**Robert Barefoot
West Stewart St**

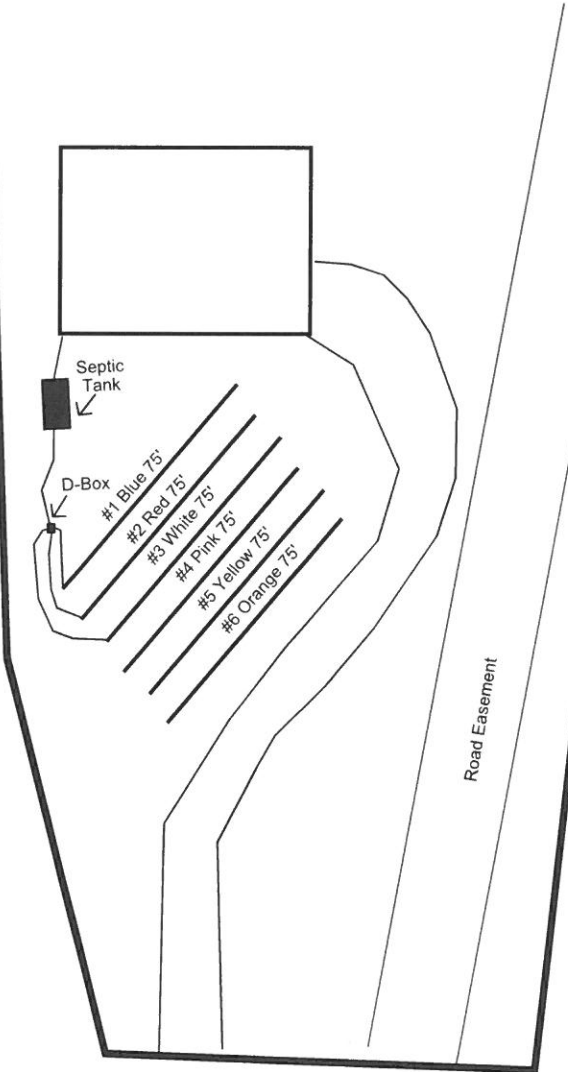
* SOIL LAYOUT
 CONSISTENT W/
 REPORT BY ADAMS
 SOIL CONSULTING

* DRW SHALL BE
 ROUTED AROUND
 SEPTIC AREA
